atelier consultants
old rectory cottage
55c Kingston lane
Southwick
bn42 4sp

Re. LU/295/17/PL – Land to South of Unit 1, Arunside Industrial Estate.

Further to your letter dated 22nd.September 2017, we respond as follows to the points contained,

EAST ELEVATION

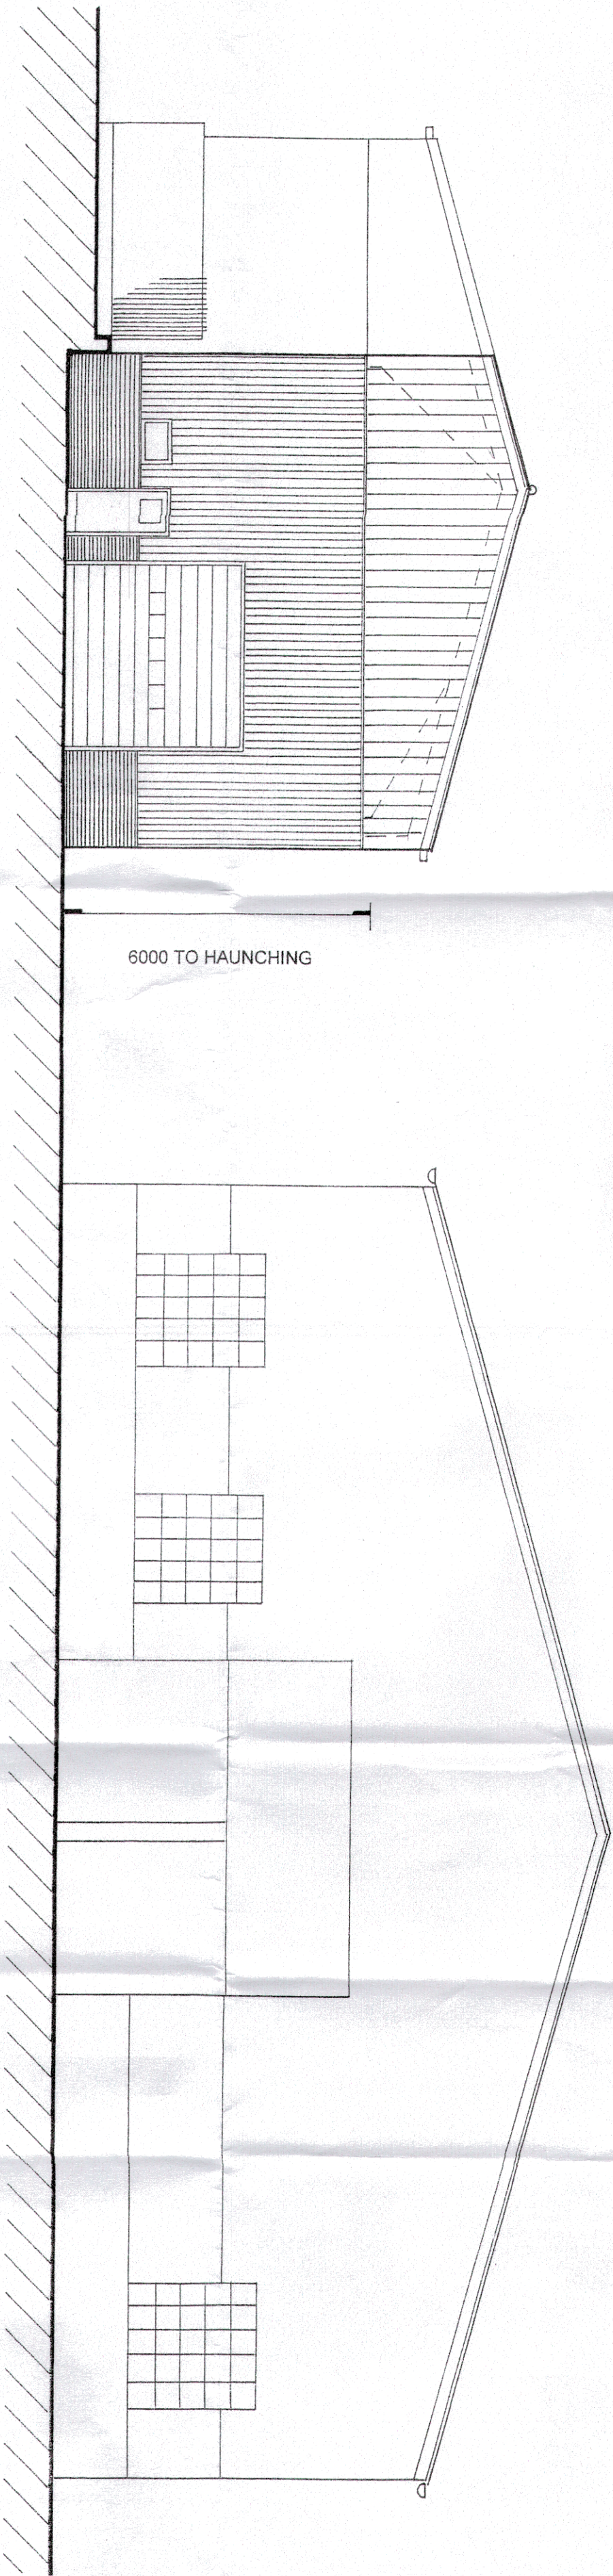
1. East Elevation,

The wall is considerably set back from the elevation plane therefore not shown, however we have added the door to the east elevation as you requested and the amended drawing is enclosed.
